Re: Request for further information R/147/20/HH

Subject: Re: Request for further information R/147/20/HH

Ocean View, 87, Sea Avenue, Rustington, West Sussex, BN16 2DR

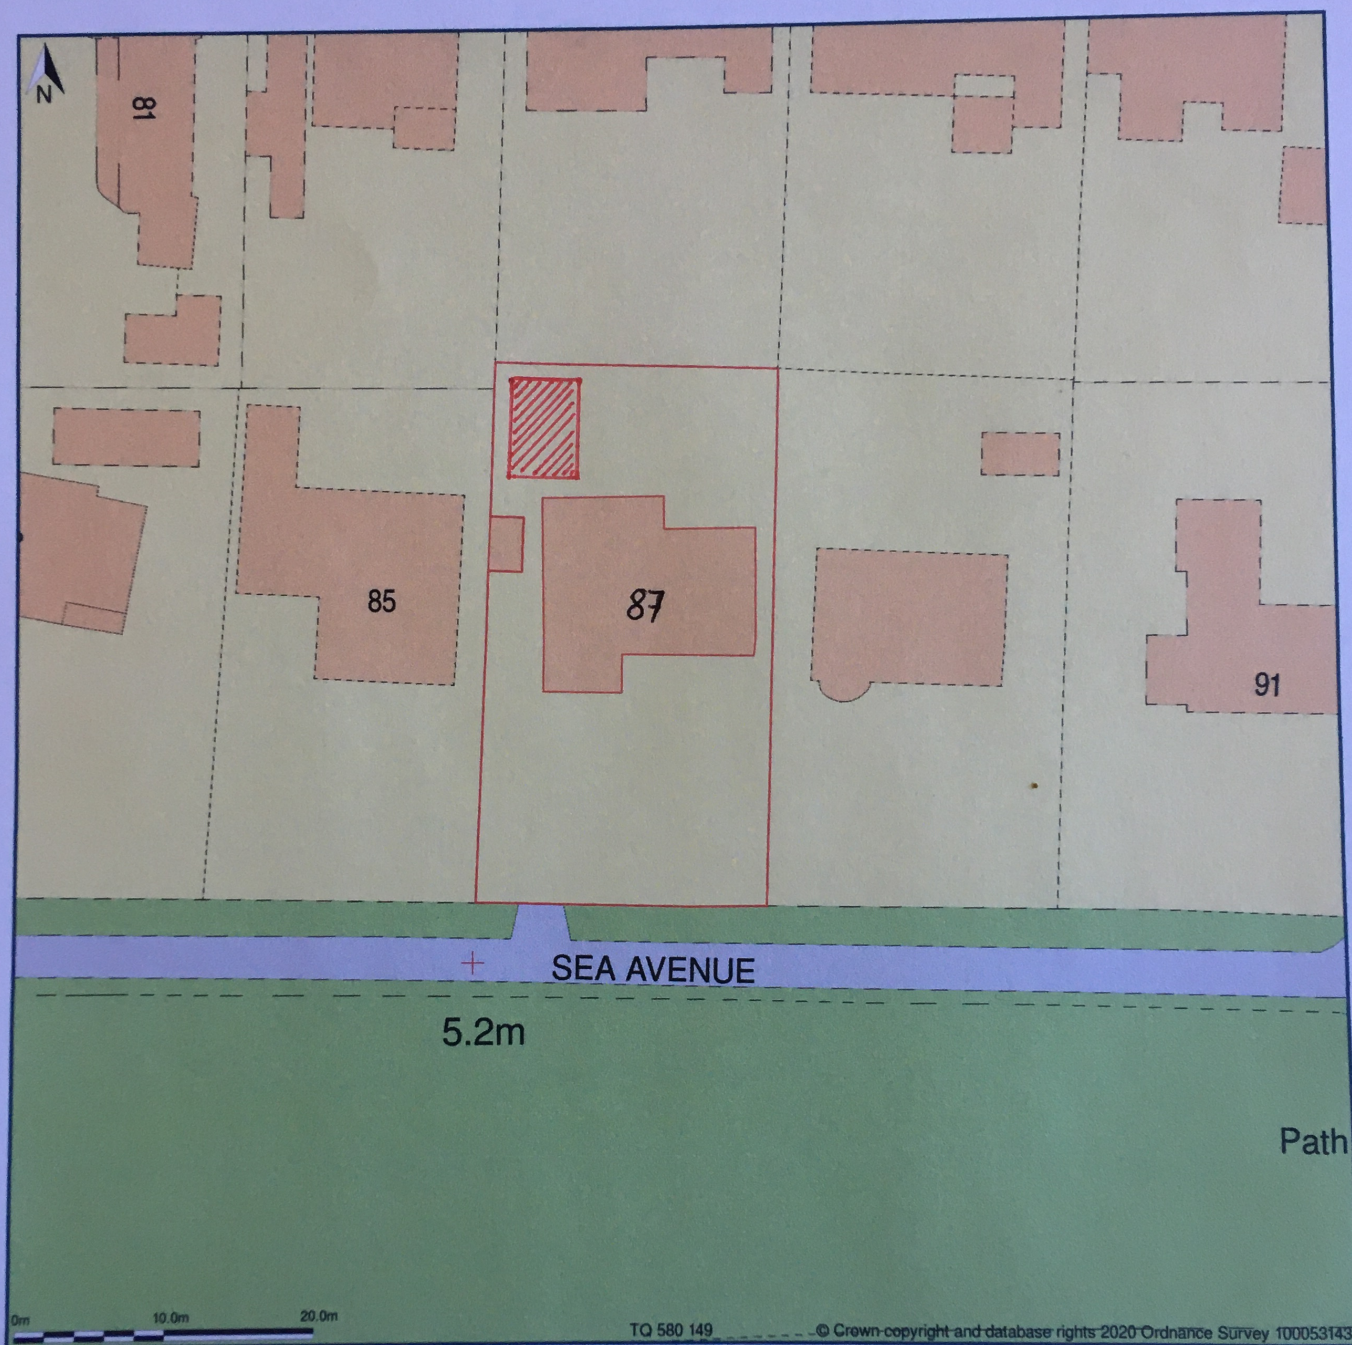
It would be very helpful if you would add the dimensions from the outbuilding to all site boundaries on the Block Plan. My apologies, I hadn't realised that this was needed.

Thank you for your email, the block plan requires dimensions from the outbuilding to all site boundaries. With your permission I can add these for you. We are also awaiting the floor plans/elevations as PDF documents as they cannot be measured/uploaded when they are not PDF.
